The Applicant is requesting an update to the existing Site Plan-DRB for minor revisions to certain sidewalk configurations, transformer locations, maintenance building, clubhouse building height, etc.

RE: Request for a Minor Amendment to a Site Plan – DRB

The purpose of this letter is to request a Minor Amendment to the existing Site Plan-DRB for the property located at 6700 Modesto Avenue NE. The Applicant is requesting an update to the existing Site Plan – DRB for minor revisions to certain sidewalk configurations, transformer locations, maintenance building, clubhouse building height, etc. The current Site Plan was approved by the Development Review Board (DRB) on May 5, 2021 (Project #PR-2019-002761).

**A4.11**  
 20213

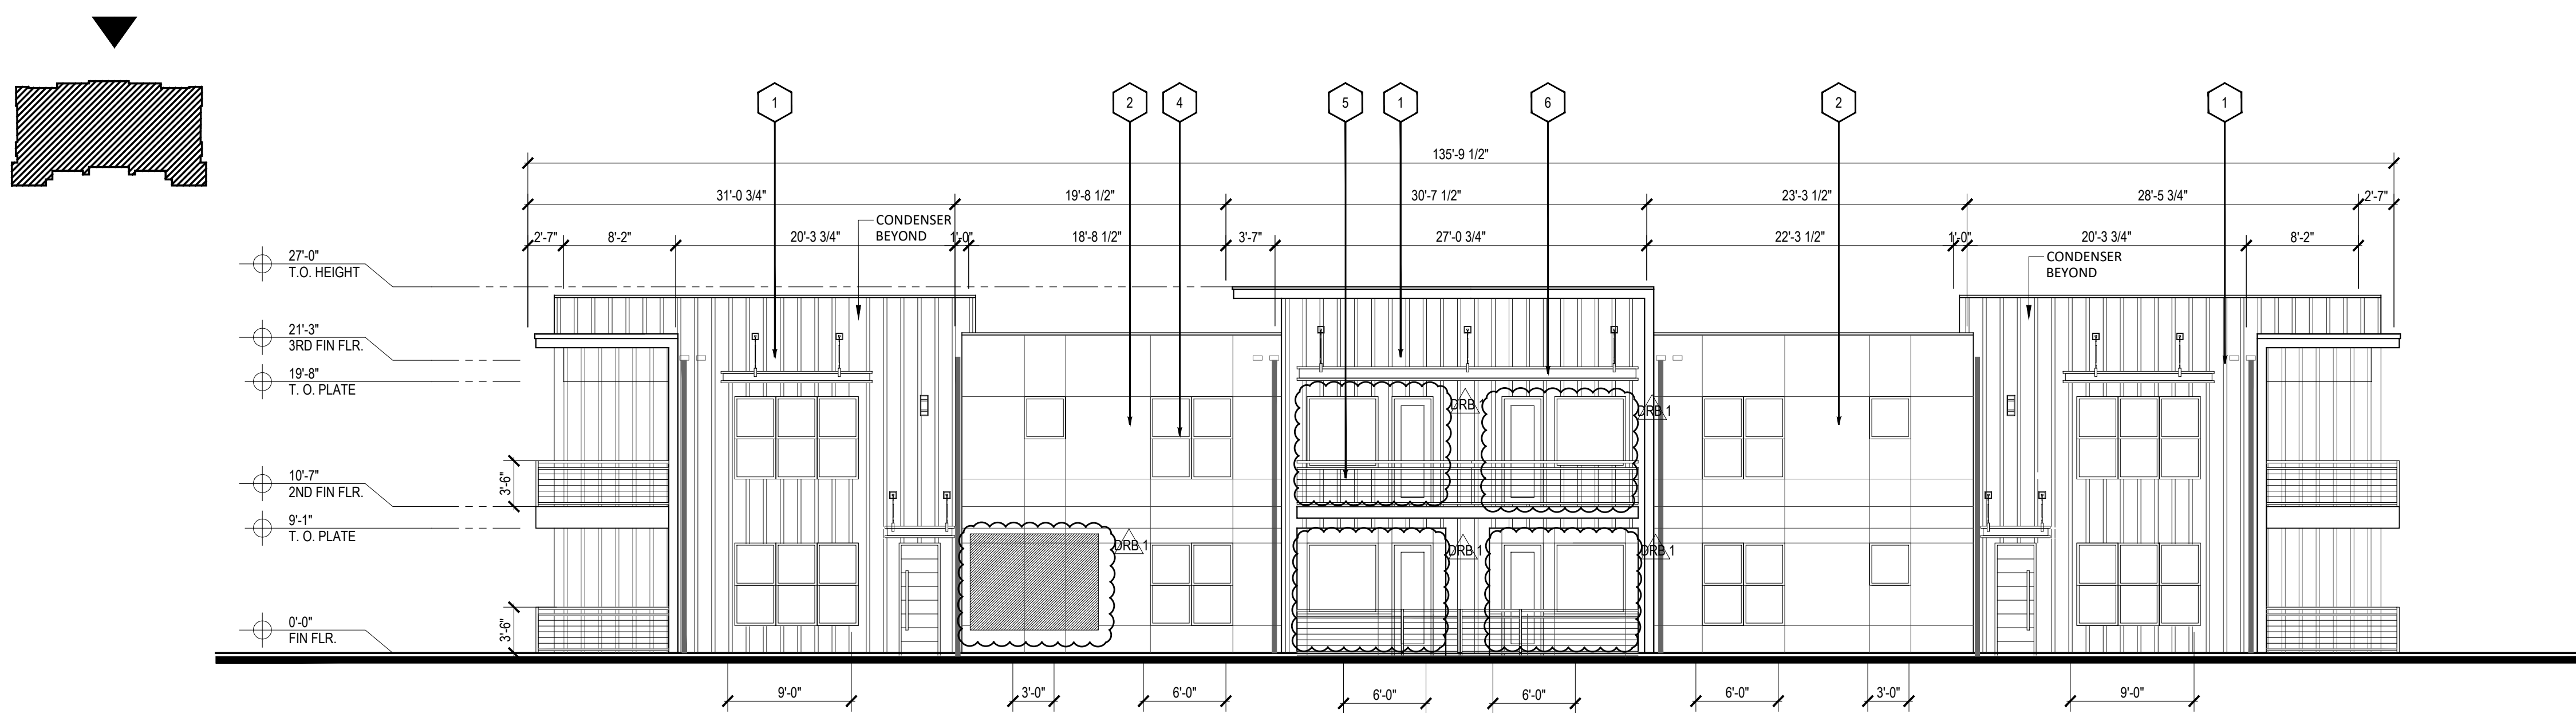
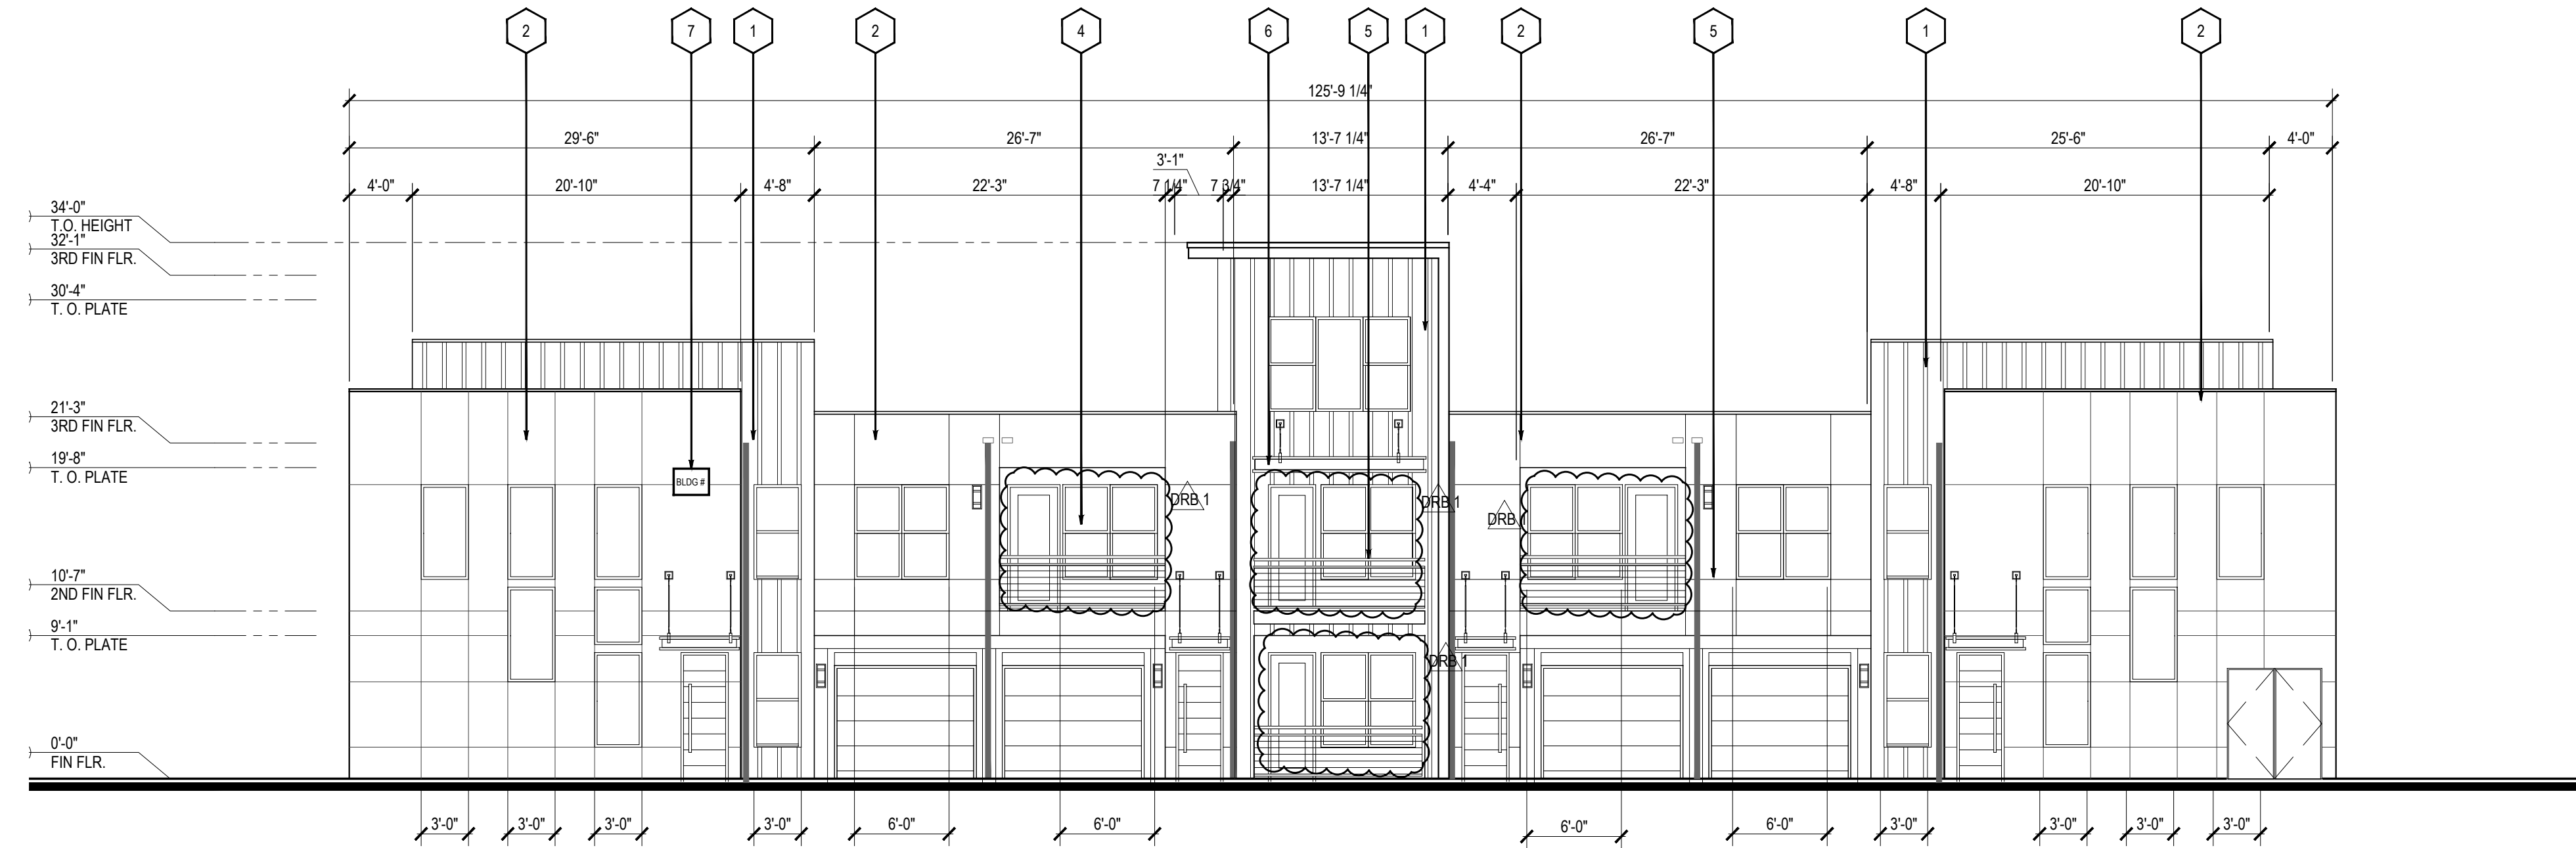
A4.11, 21, 31, 41 Building Type I, II, III, IV Building Elevations

- Updated windows, added meter locations.

SHEET CONTENTS:  
 CLUBHOUSE ELEVATIONS  
 SHEET NO.  
**A8.02**  
 20213

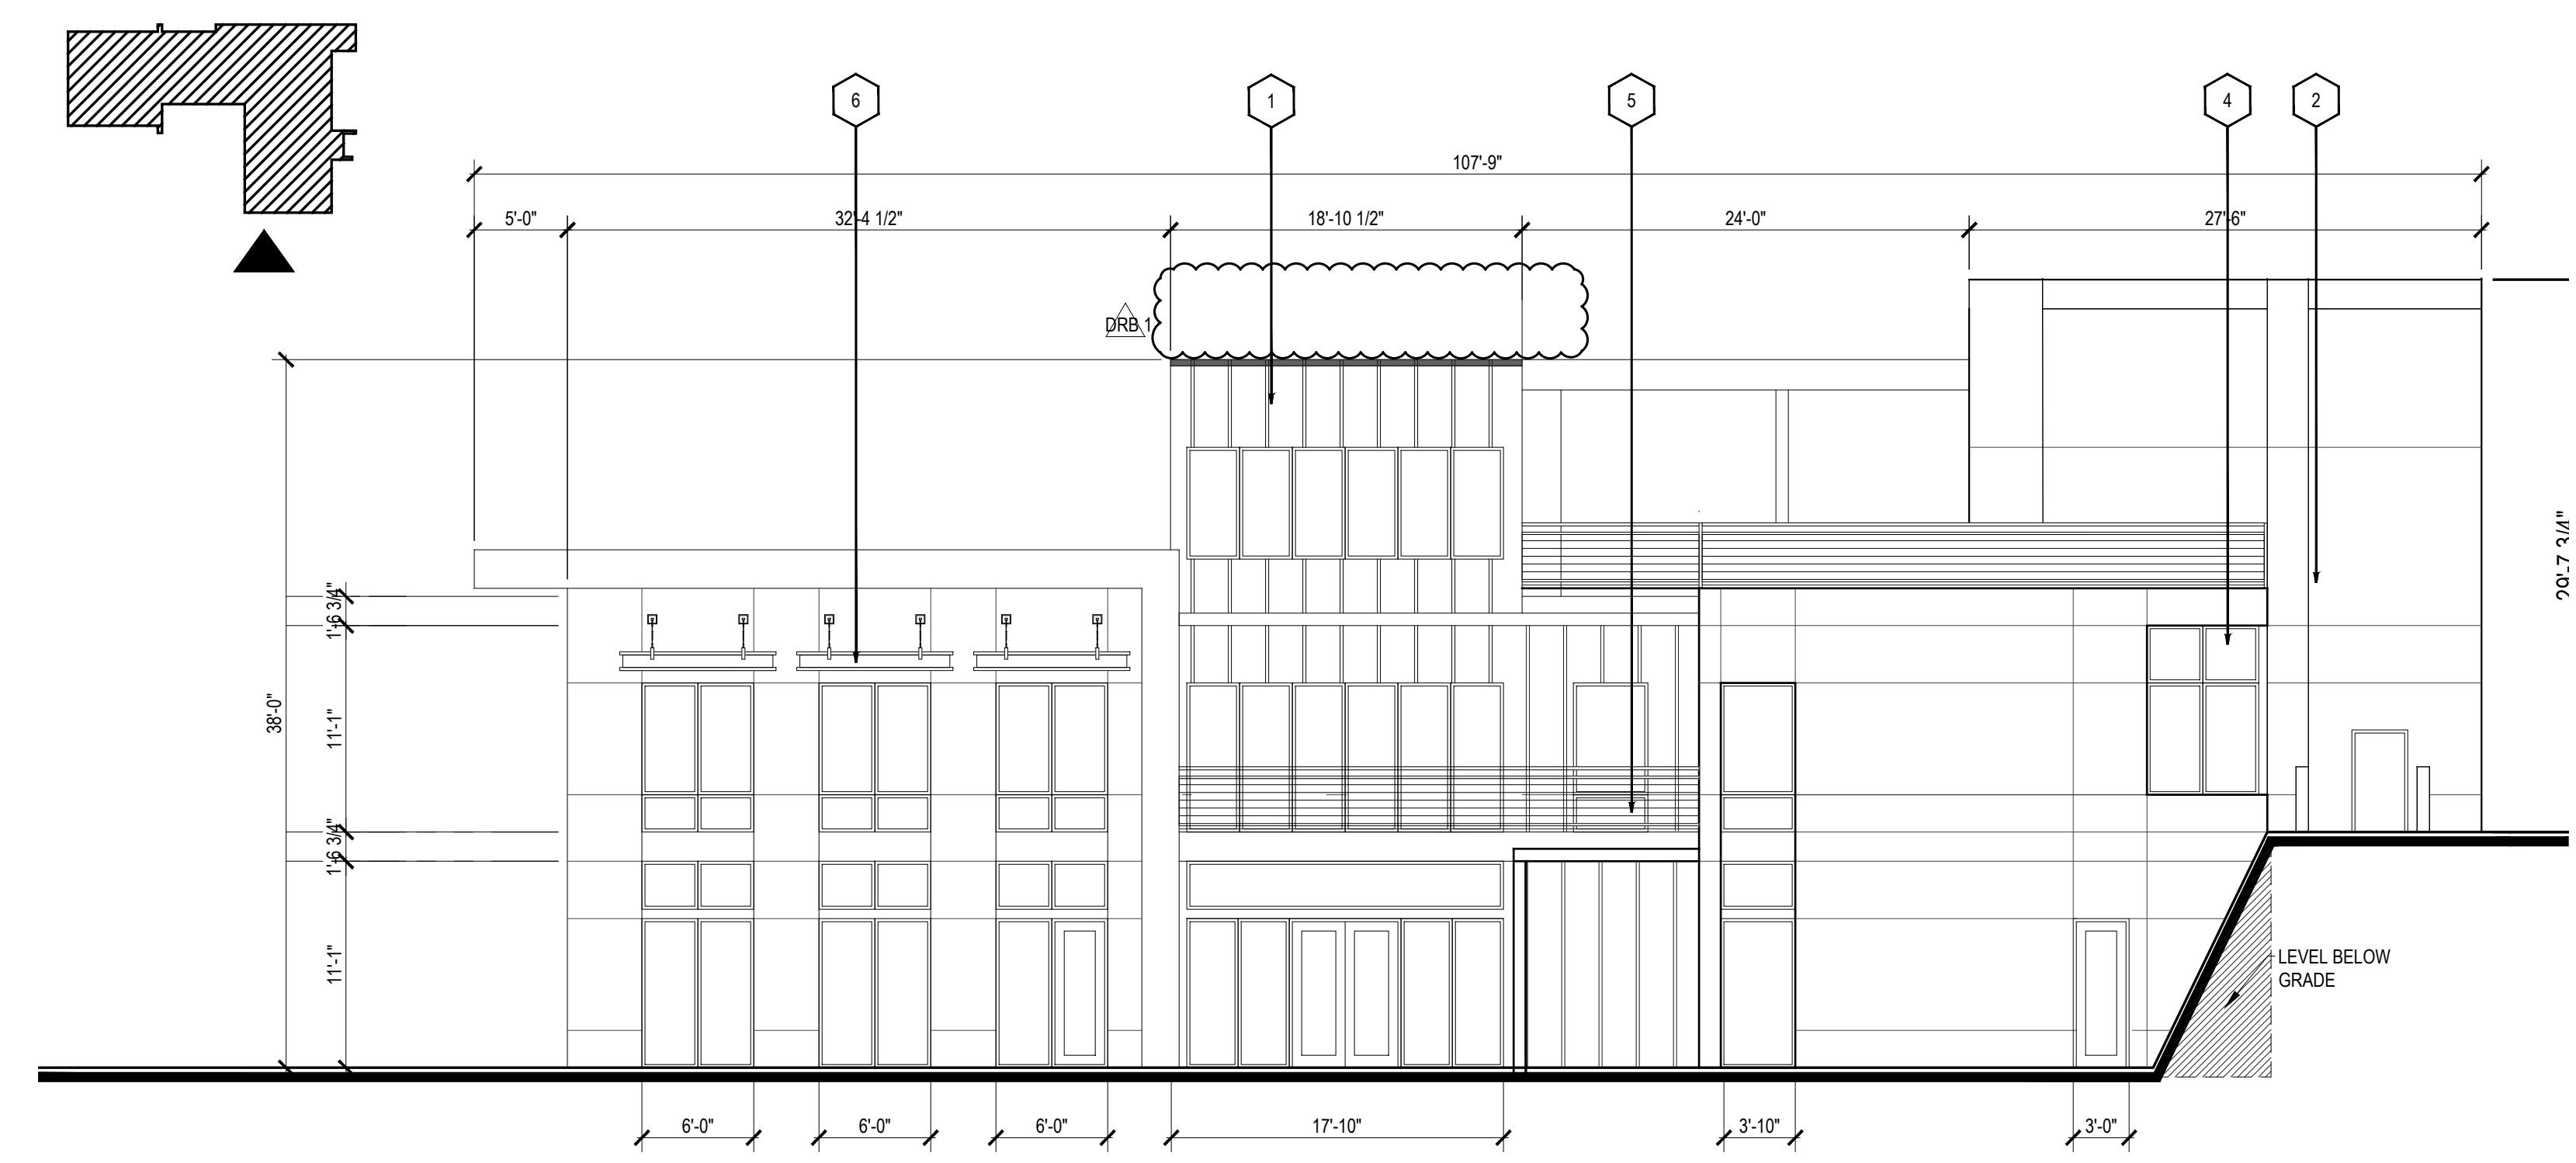
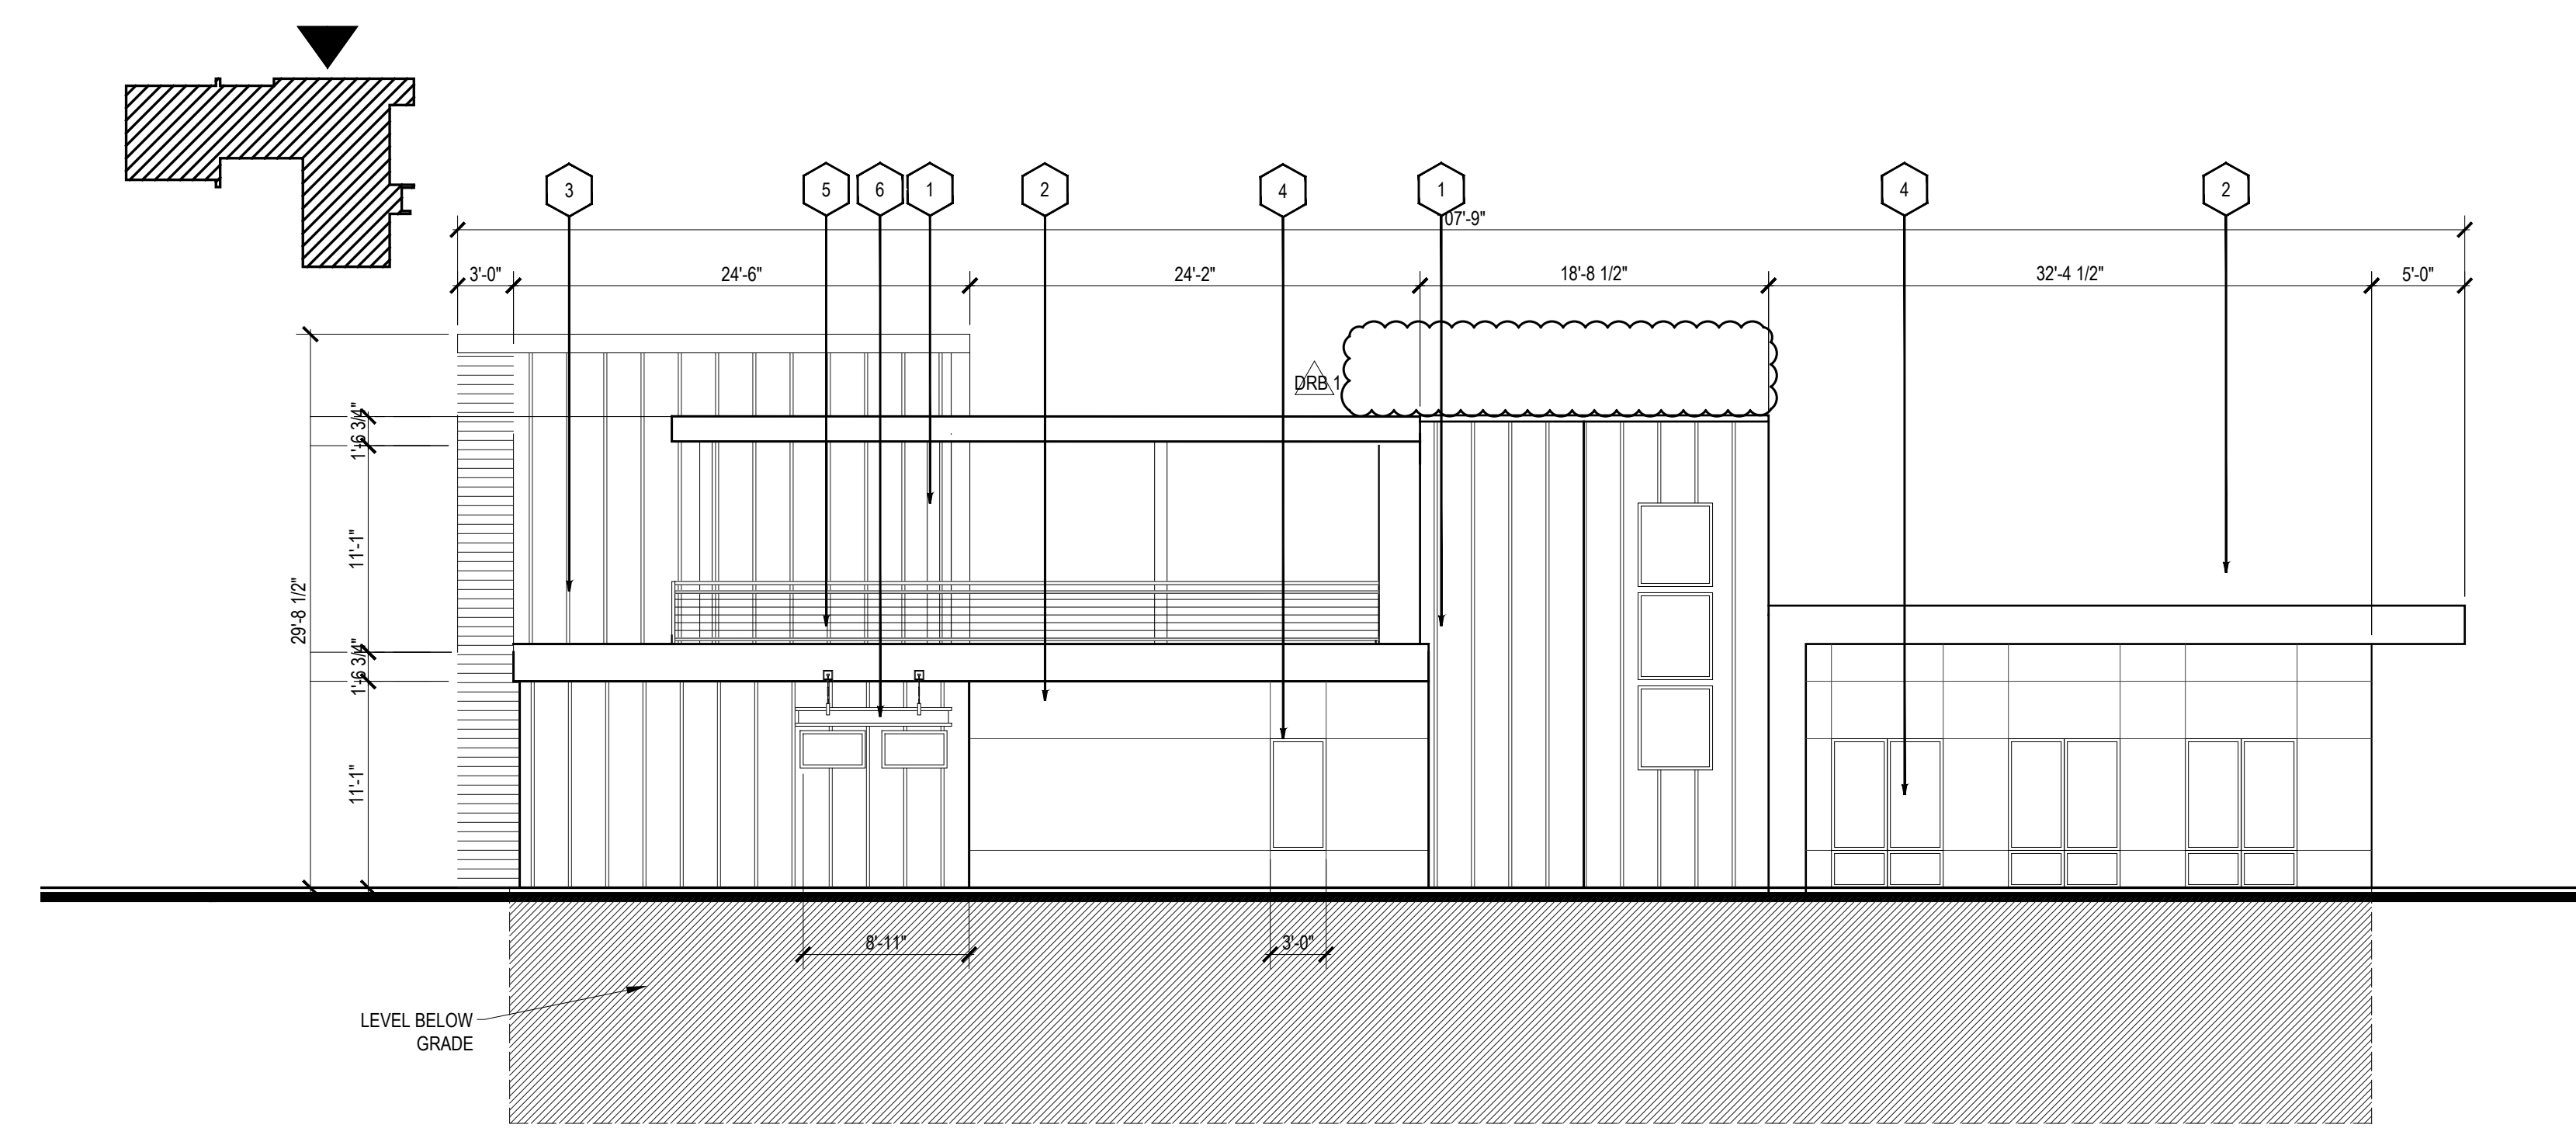
A8.02 Clubhouse Elevation

- Building height has been reduced.
